Five Estuaries Offshore Wind Farm Case  
Team  
Planning Inspectorate  
[FiveEstuaries@planninginspectorate.gov.uk](mailto:FiveEstuaries@planninginspectorate.gov.uk)  
**(By Email only)**

MMO Reference: DCO/2019/00008  
Planning Inspectorate Reference: EN010115  
Identification Number: 20049306

## **Planning Act 2008, Five Estuaries Offshore Wind Farm Ltd, Proposed Five Estuaries Offshore Wind Farm Order**

### **Additional Submission**

Figure 2-3 Mean herring larval lengths per sampling station (IHLS survey data (2012 to 2017) – Netherlands (January)

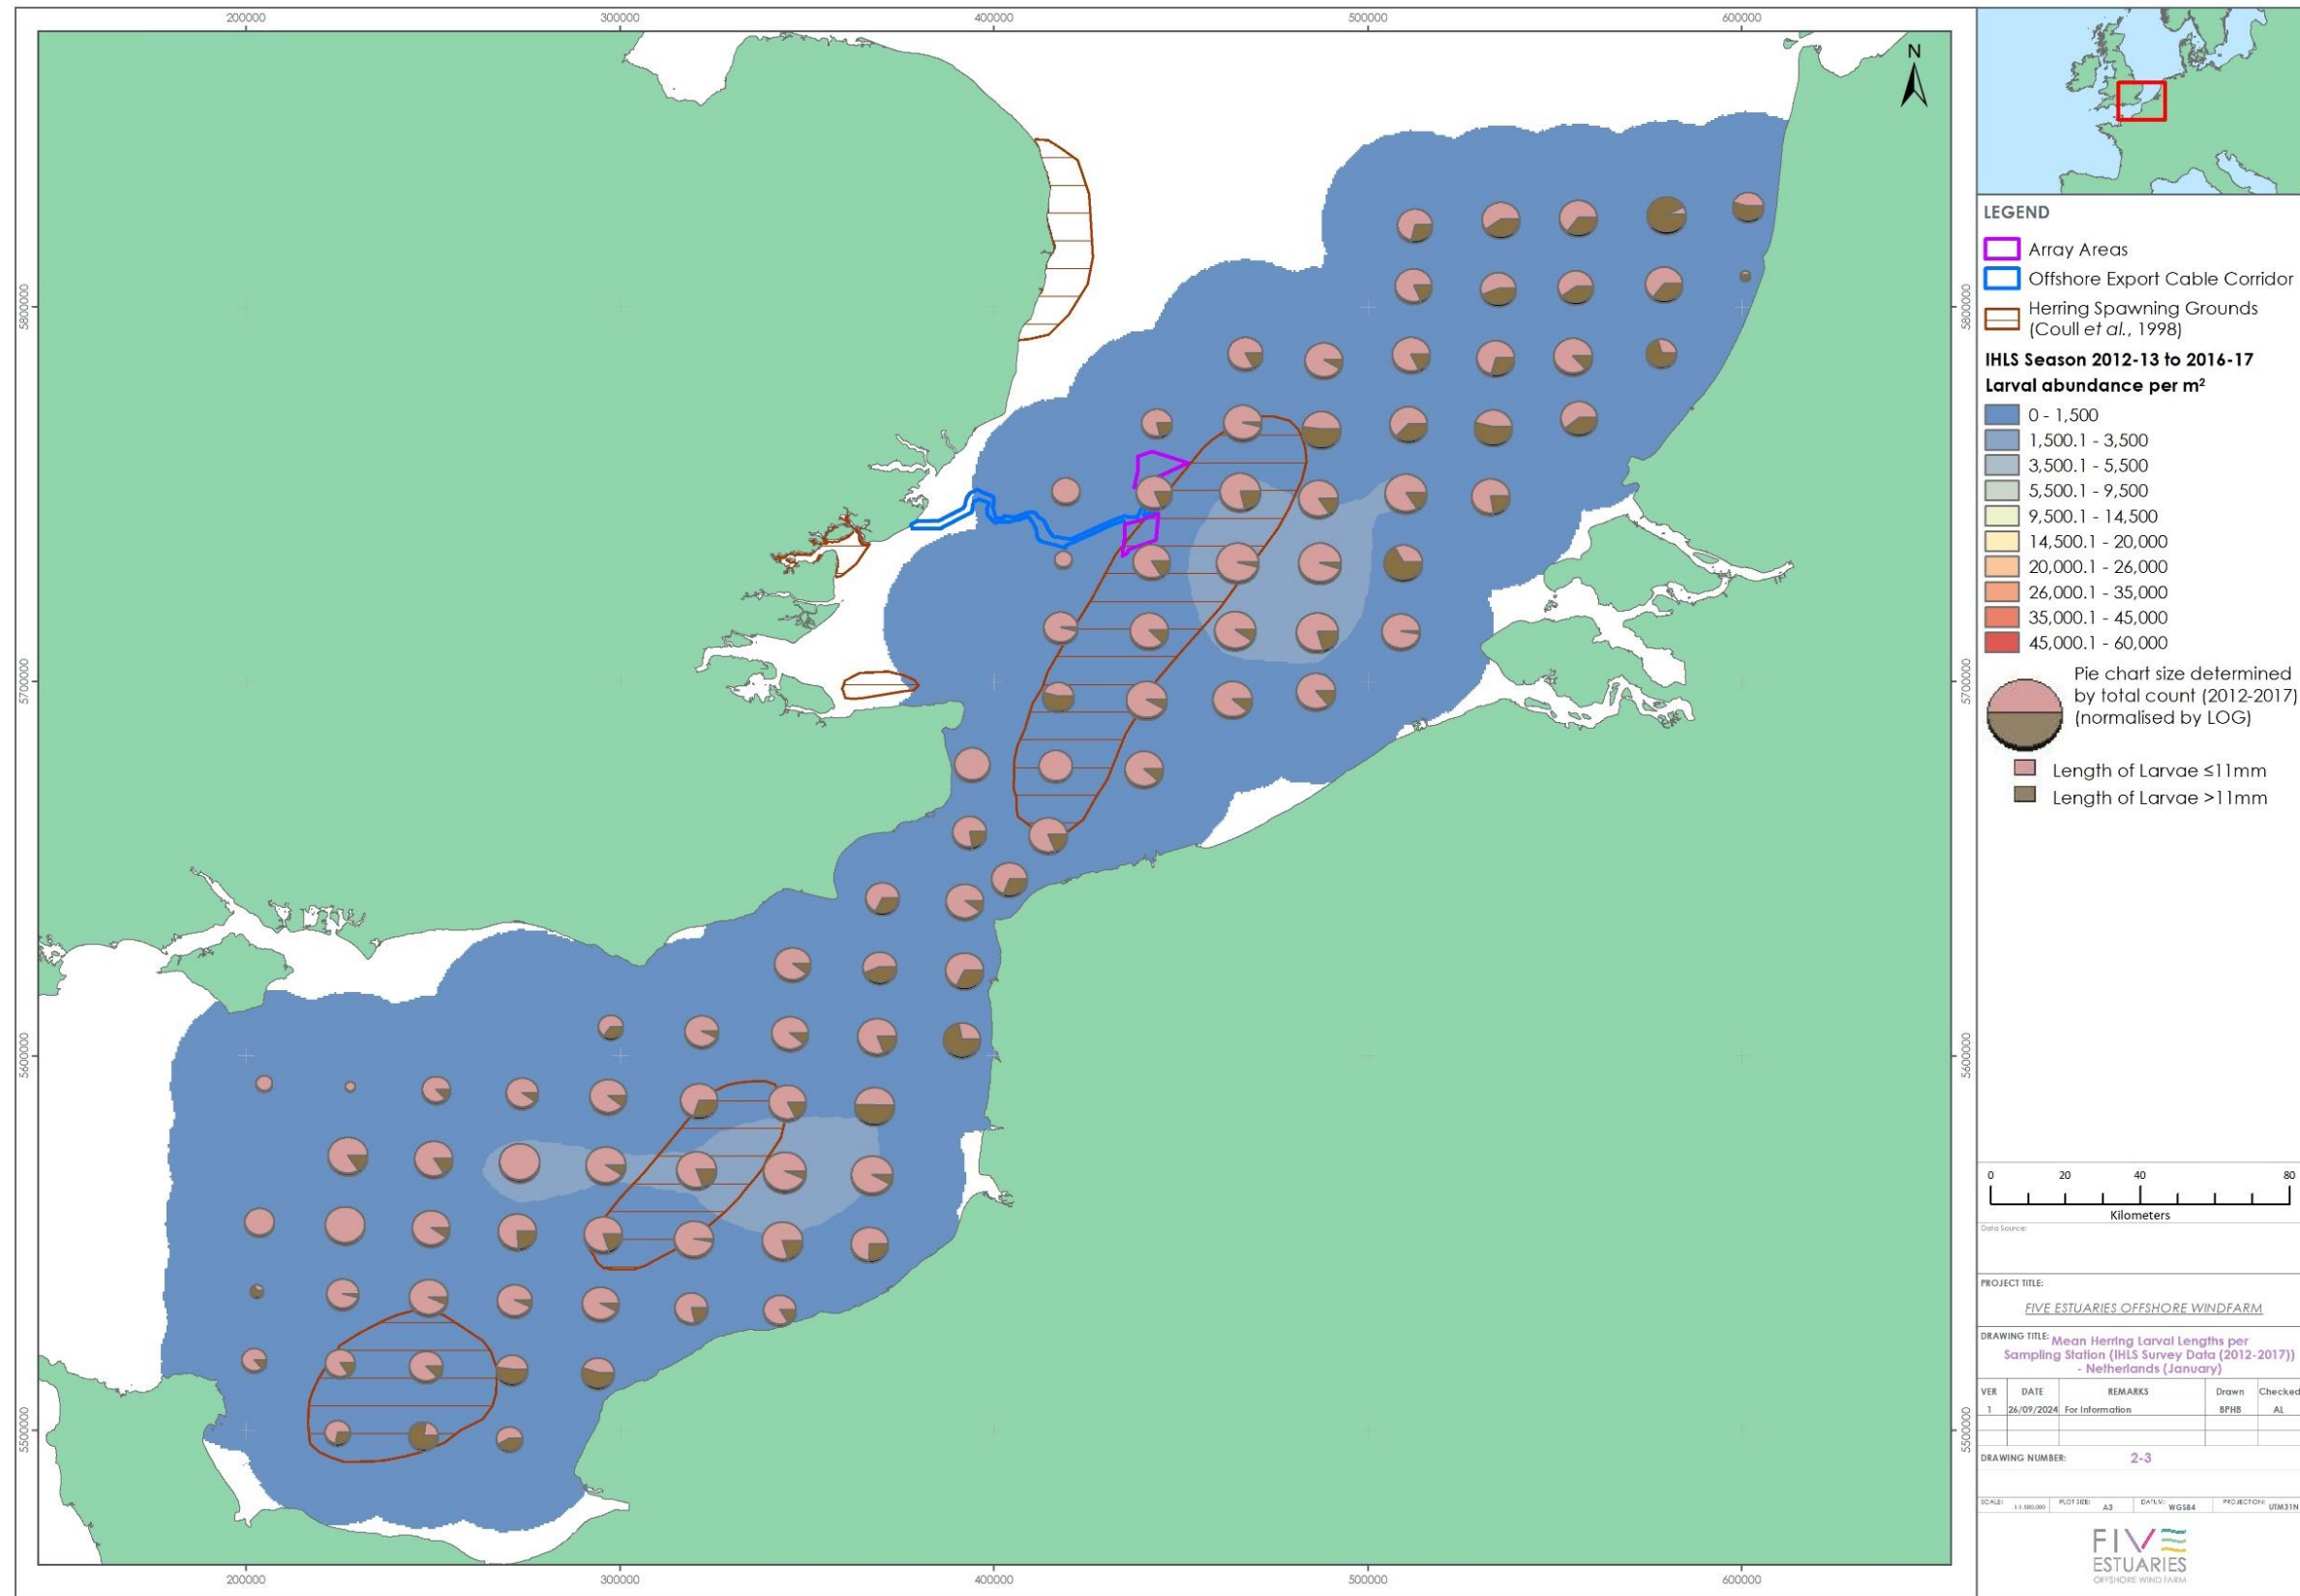
1.2.5. The MMO notes the Applicant has reviewed the IHLS larval length (catch length) data and plotted the mean herring larval lengths per sampling station from the IHLS data over a 10-year period (2012-2024) for each of the three survey periods (16-31 December, 1-15 January and 16-31 January) in Figures 2-1, 2-2 and Figure 2-3, respectively. Using this data, the Applicant has determined that a larval catch length of 11 millimetres (mm) is appropriate for use in the back-calculation. This length is
